Dr. Houser Dental Office Addition – Minor Site Development Plan Letter of Intent

Location: Falcon Dental, 8011 Meridian Park Drive, El Paso County

SITE PLAN
 SCALE: 1"=10'-0"

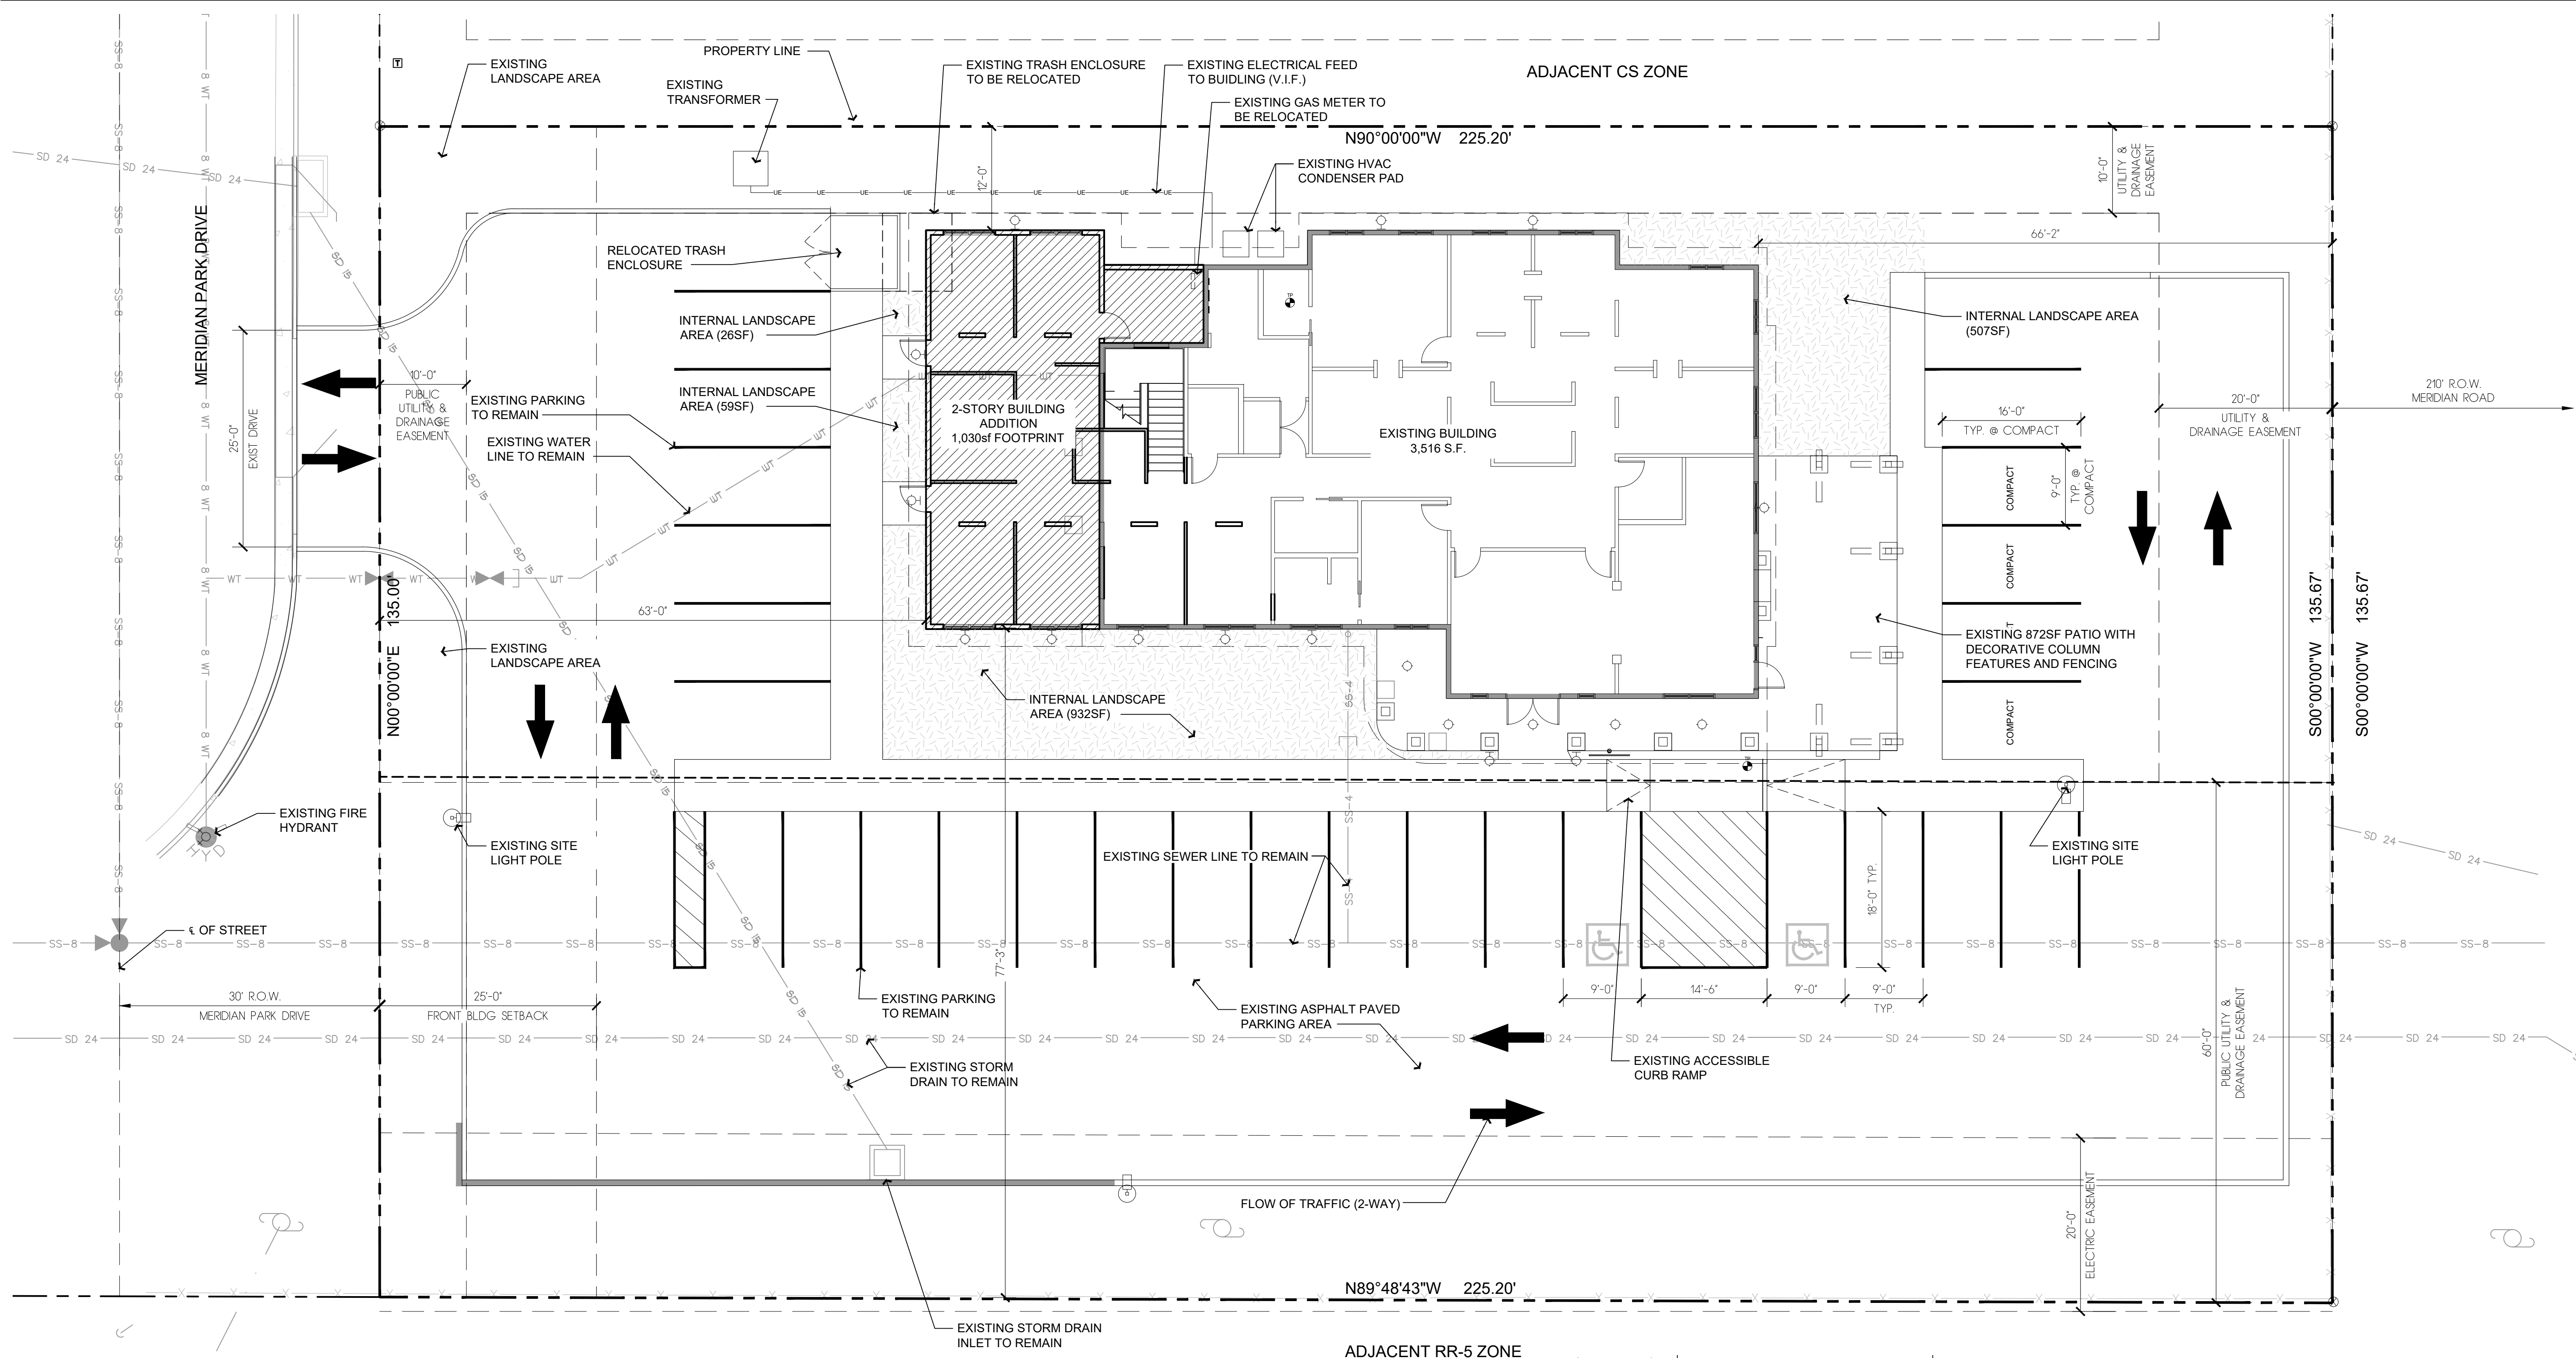
The plan that was approved in 2018 does not seem to fully comply with the current Land Use Code. There are no landscape islands (or fingers) that terminate the parking rows and no islands exist within the 16-space parking row. It seems apparent that trying to meet this requirement would require the re-striping of the lot and end up reducing the parking to less than what is required. With consideration for this situation, we request that the consideration of an “alternative landscape plan”, that provides the required tree quantities but without the parking lot landscape islands to avoid interfering with the existing accessible parking and overall parking quantities. Please see Request provided by Higher Ground Designs.

please explicitly request this as an "alternative landscaping plan." specify what is required vs. what you are requiring.

A tree of a type suitable for parking lots shall be provided for every 15 parking spaces in parking lots with 15 or more parking spaces. The required trees may be clustered and shall be located in a manner which will divide and break up expanses of paving and long rows of parking and create a canopy effect over the parking lot. If this will not be provided, please state as such in the letter of intent where you will need to request an "alternative landscaping plan."

- Waive motor vehicle tree island requirement.
- Justification
 - This site is existing and previously approved without shade tree islands
 - The parking space layout accommodates ADA and adding an island would interfere with the current layout
 - Two shade trees for motor vehicle space requirement are provided
